DECISION DELEGATED TO DEVELOPMENT MANAGER
--

Application No:	H16-0473-21	Applicant:	Hutchison UK Ltd
Proposal:	Proposed 15m phase 8 monopole C/W wrapround cabinet at base and associated ancillary works		
Location:	Birch Grove Spalding		
Terminal Date:	24th June 2021

Title: **210 PROPOSED H3G SITE PLAN**

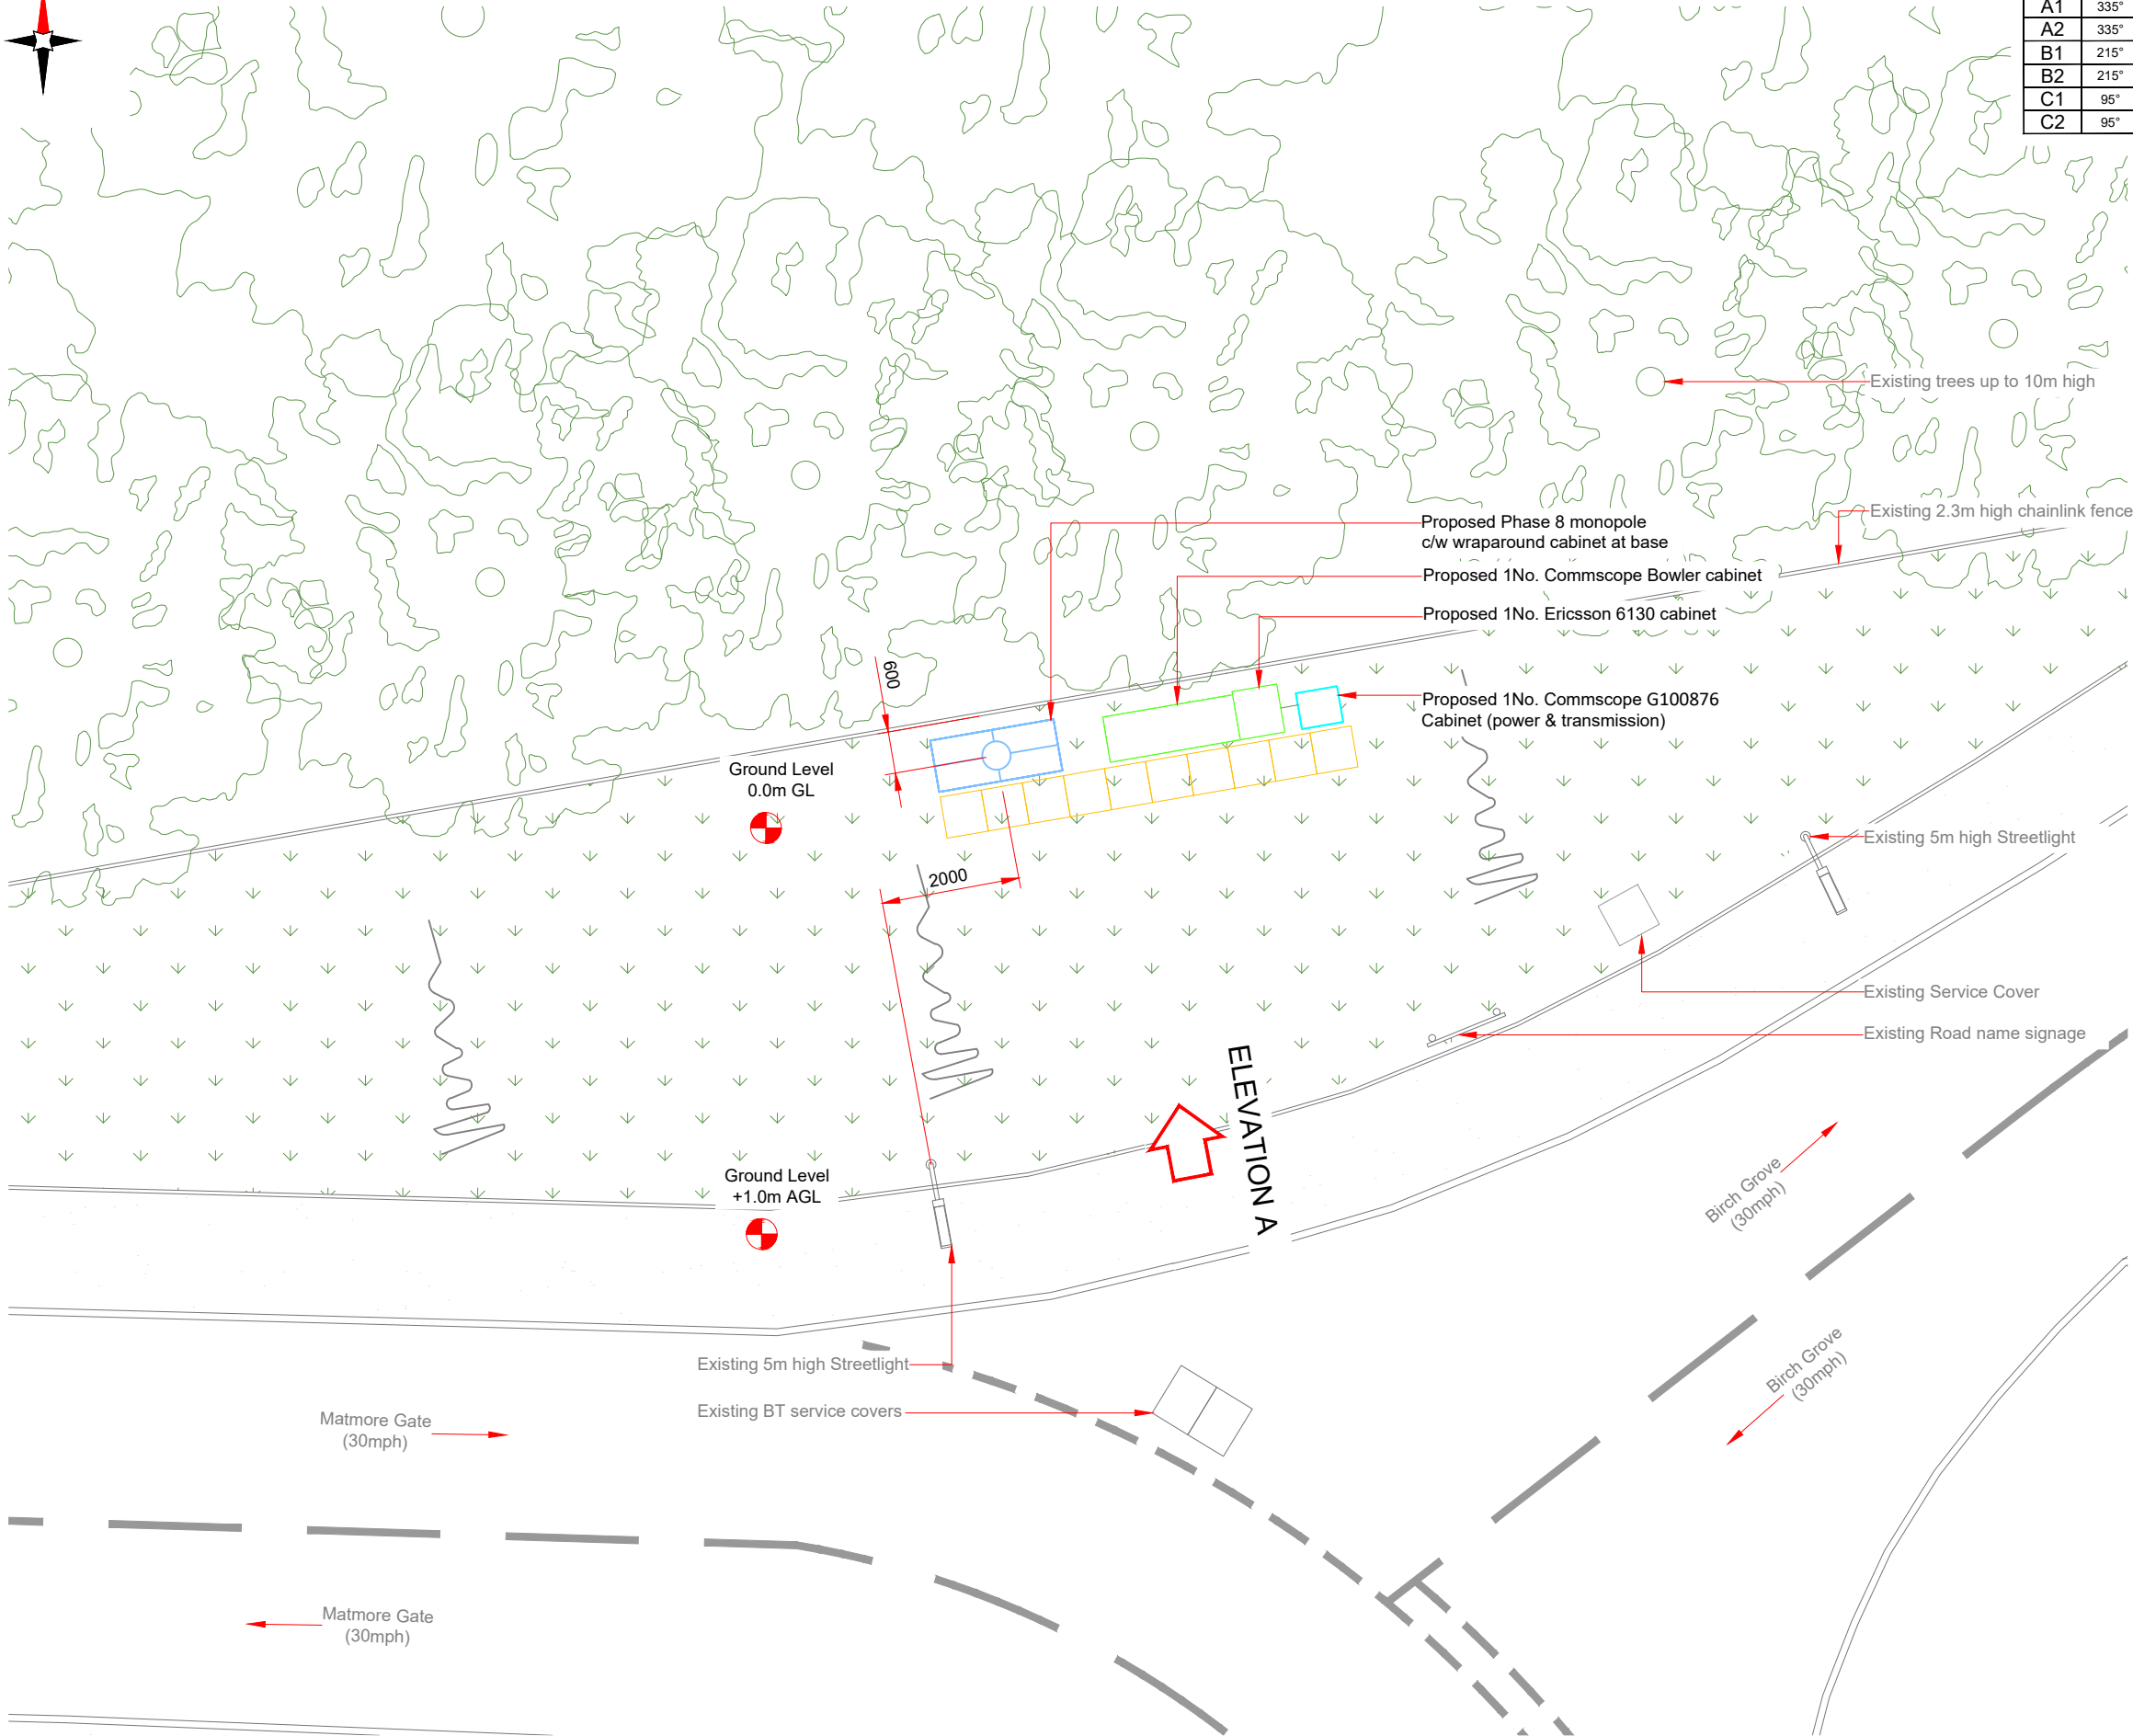
In terms of its siting, the proposed monopole, even at a reduced height of 15m, would be readily visible in the street scene and the scale is not comparable to any other structure or building in the vicinity. Although it would be seen against the backdrop of adjacent/nearby trees to the north and east, it would be greater in height than any of these trees and would be far above the ridge line of dwellings. Furthermore, it would be in a visually prominent location when exiting the residential estate to the south. Whilst it is accepted that there is other street furniture in the vicinity (such as street lights and road signs), it is considered that the proposal, even reduced in height, would have a material adverse impact on the wider street scene due to it being an unduly dominant, obtrusive and alien feature within the street scene. In light of this, the proposal is considered to be unacceptable in terms of its siting and contrary to Policies 2 and 3 of the South East Lincolnshire Local Plan (2019). Policy 2 of the Local Plan requires development proposals to take into account sustainable development considerations such as: size, scale, layout, impact on character and appearance of the area and the relationship to existing development. Policy 3 requires development

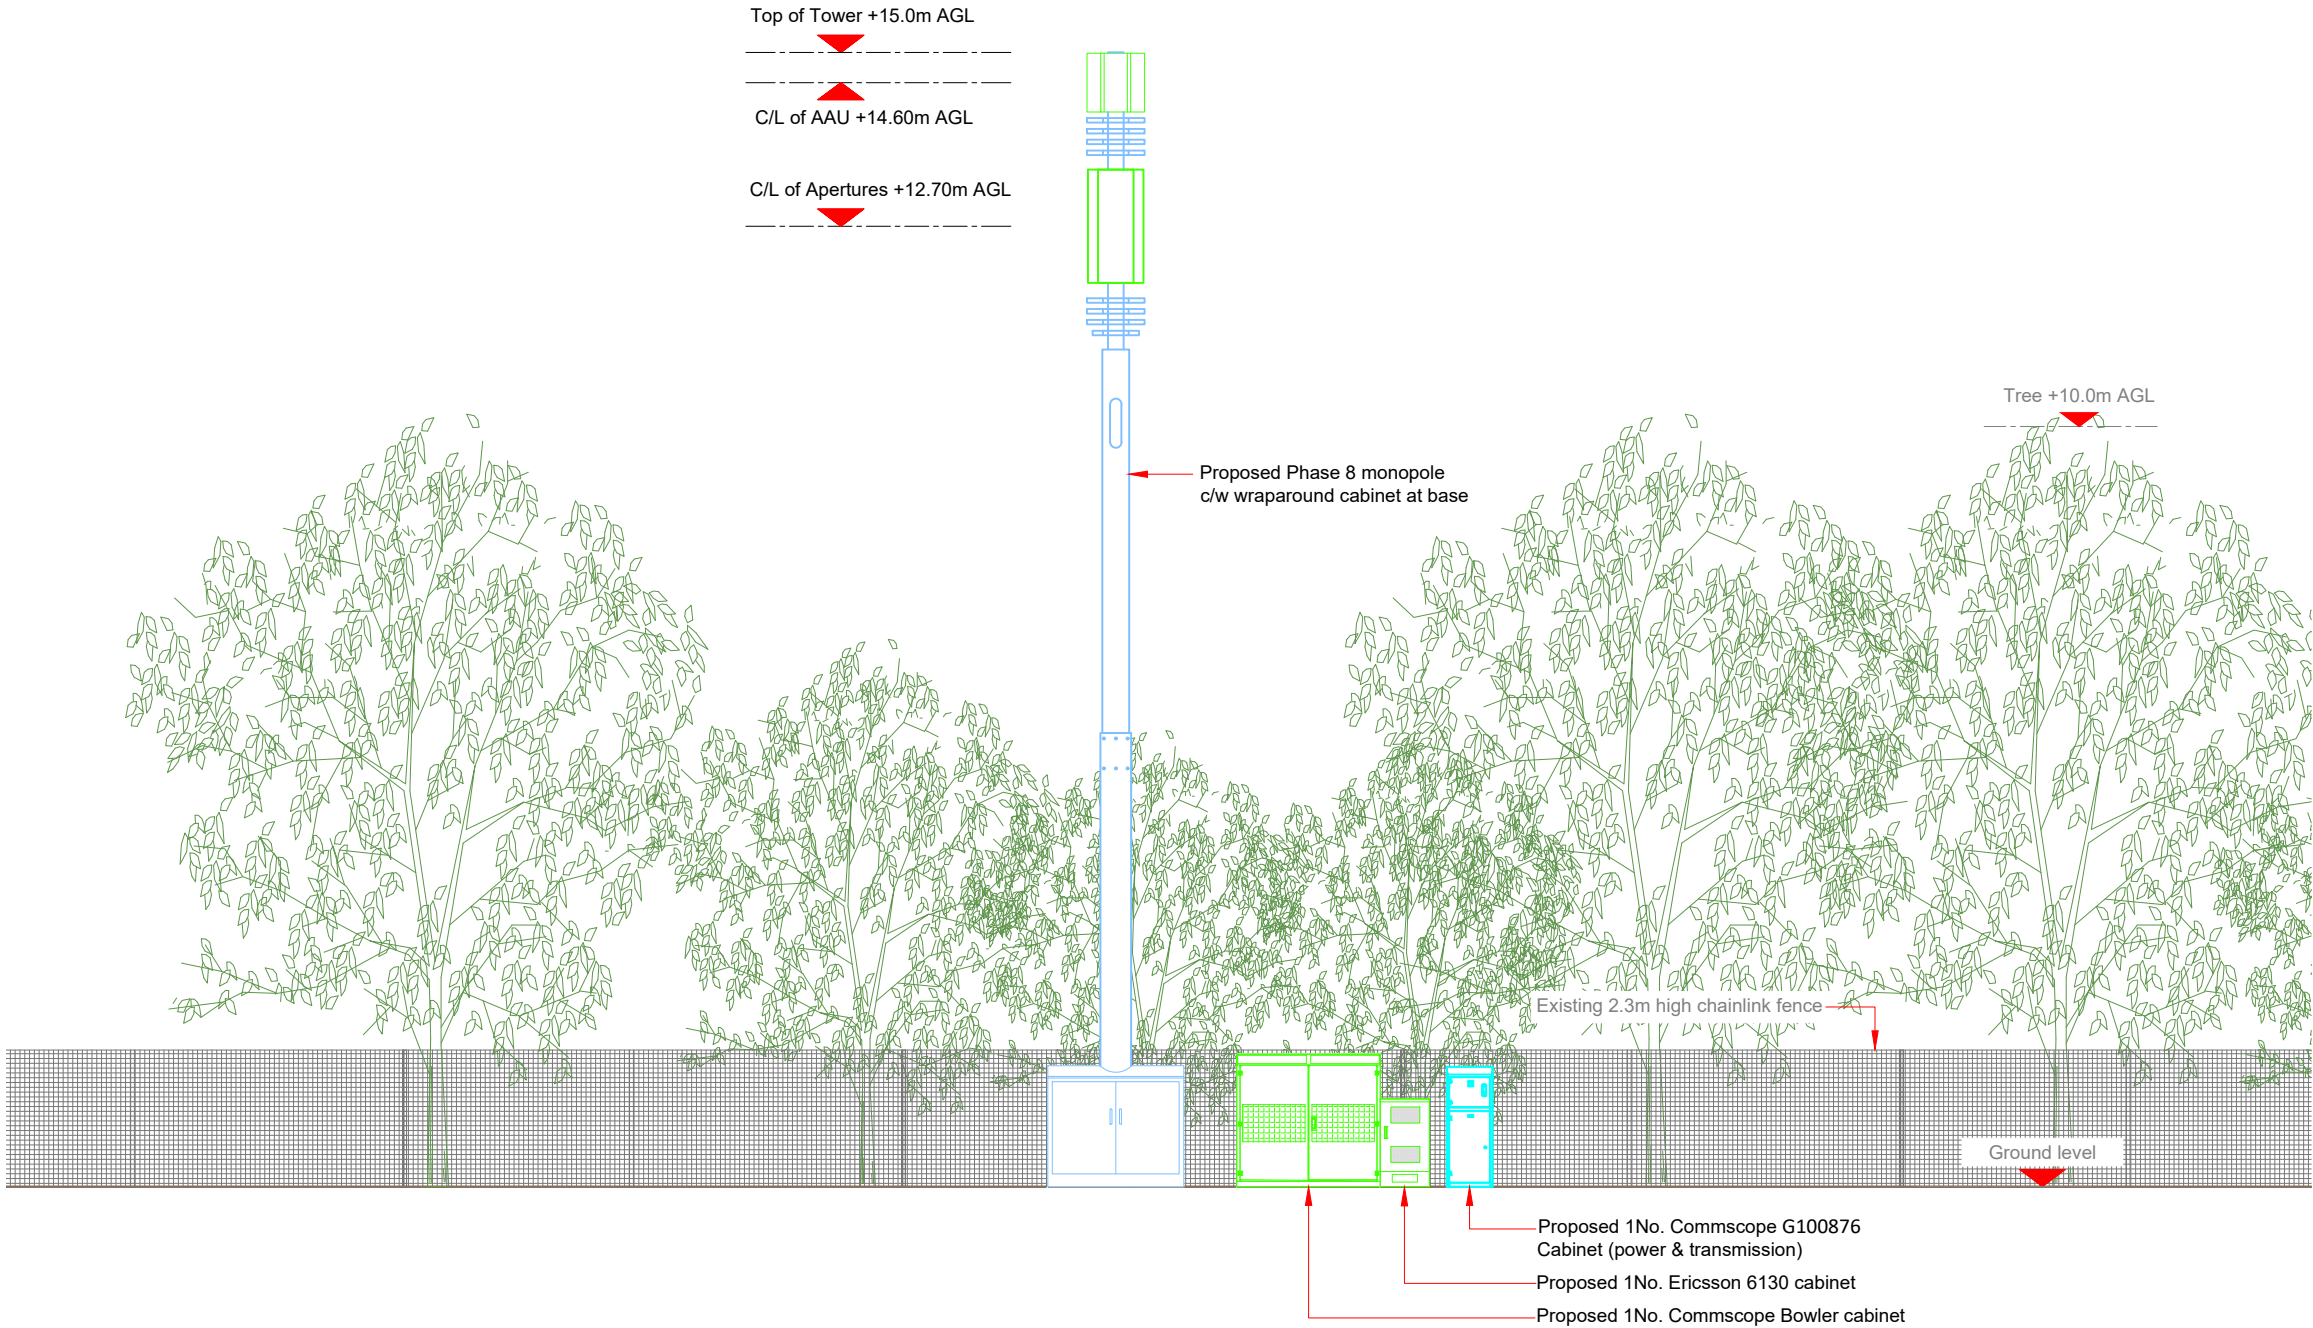
In terms of appearance, the proposal is of a functional design and a typical appearance of such communications infrastructure. It would likely be impractical for this piece of infrastructure to be designed in a different way. If permission were to be forthcoming, a condition could be imposed requiring the structure and base cabinet to be green in colour to improve the visual appearance.
